July 10, 2024

Curtis Cherne, P.E., Senior Engineer  
City of Albuquerque Planning Department  
600 2<sup>nd</sup> St. NW  
Albuquerque, NM 87102

Re: [2023065] – OPUS Transport Apartments – Flightway Ave. at University Blvd. in Albuquerque, NM.

The purpose of this letter is to provide the responses and clarification to comments and questions from the City of Albuquerque pertaining to the draft Traffic Impact Study associated with the subject project, OPUS Transport Apartments located at Flightway Ave. at University Blvd. in Albuquerque, NM.

Figure 17: Proposed Striping and Intersection Mitigation

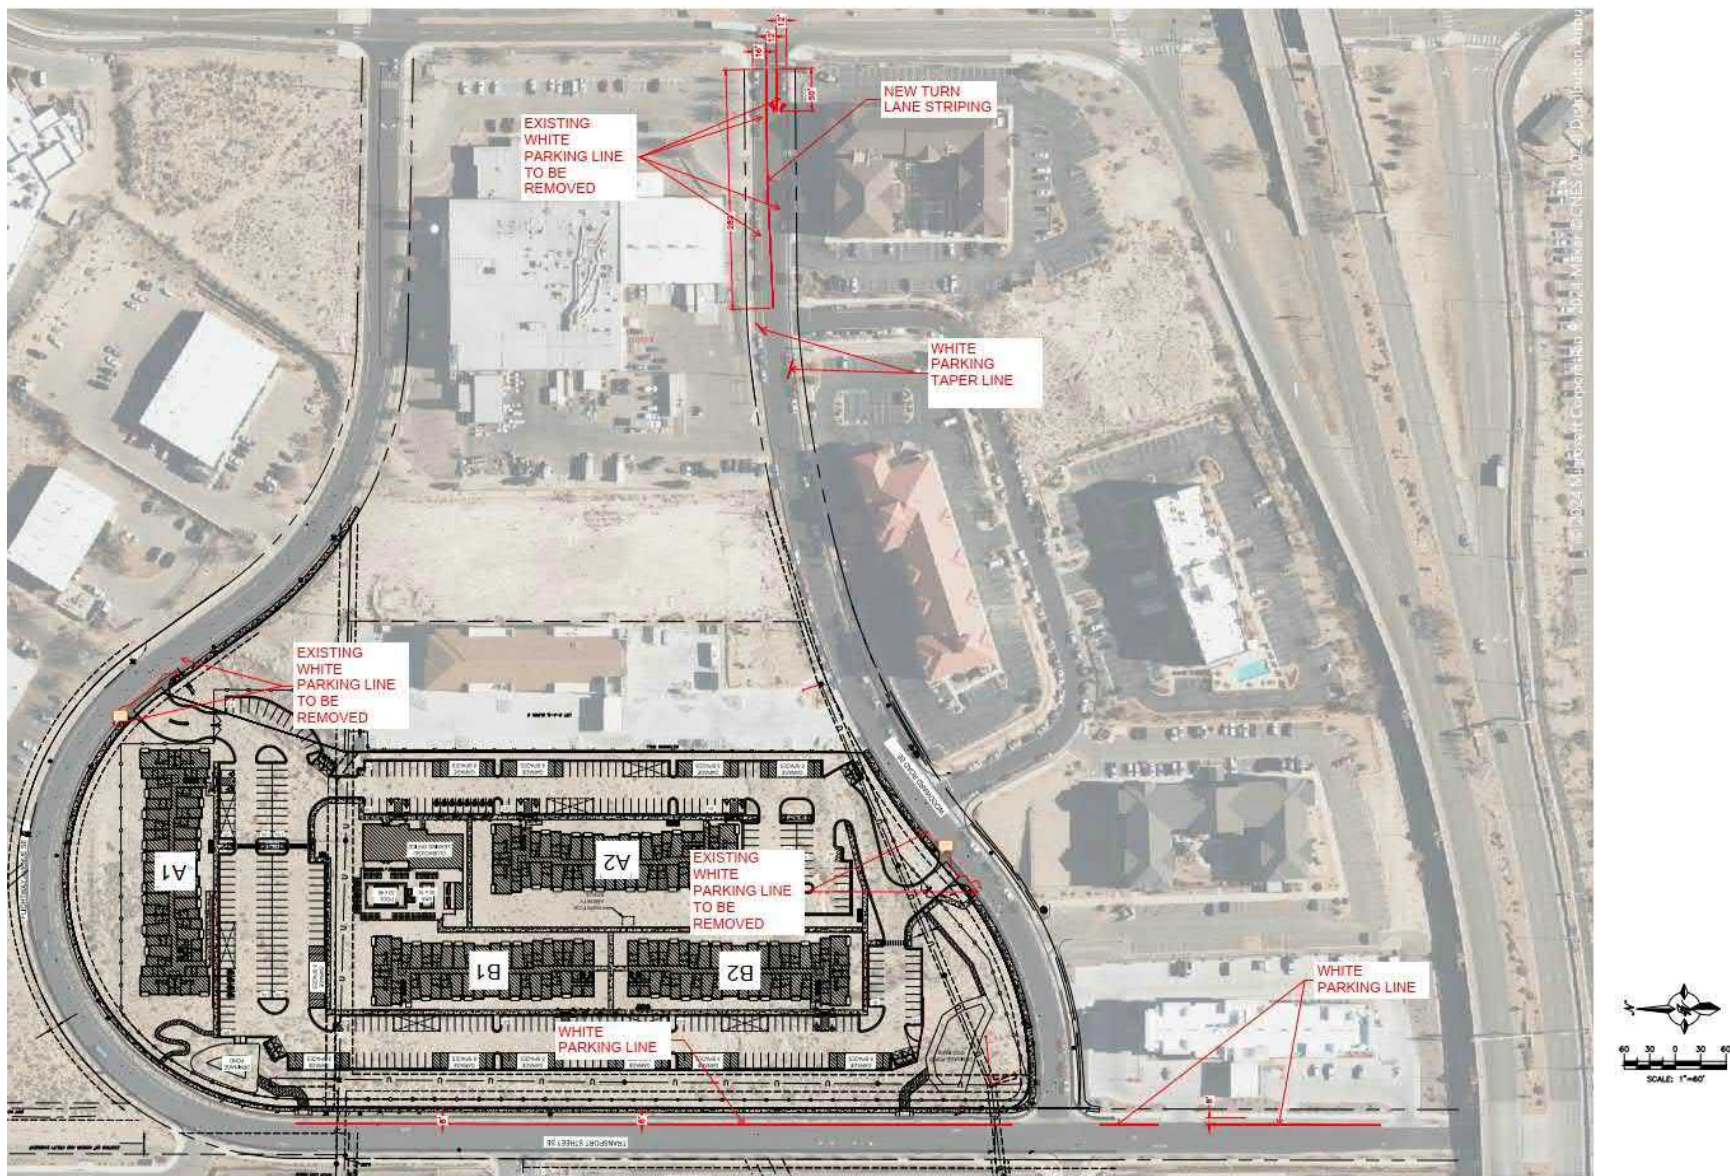
- c) Please extrapolate/provide details on the recommendation “Striping is recommended along the entire roadway to delineate lanes...”.

*Response: Tierra West LLC. has expounded on the recommendations to stripe the existing roadway with the following details beyond what is existing. Existing roadway markings include lane striping at the intersection of Flightway Ave. and University, delineating an exclusive left-turn lane and right-turn lane. The yellow center line markings extend 350 ft west from the stop bar to end of “No Pass Markings” delineating the eastbound and westbound movements. On street parking is available on the north and south sides of both Flightway Ave. and Woodward Rd.*

*The recommendation is to continue on-street parking along Transport St. on the east and west sides, as well as recommended improvements to the existing on-street pavement marking. Improvements include the striping of the parking space to meet MUTCD Section 3B.27 Parking Space Markings standard applies the following:*

*Although the Warrant for the Center Line is not met, engineering judgment was used to recommend continuous stripping beginning on Flightway Ave. from University Blvd. intersection west toward Transport St.*

*These recommendations and explanations have been added to the report in a new section named Improvements to Existing Conditions in both the Executive Summary and the report.*
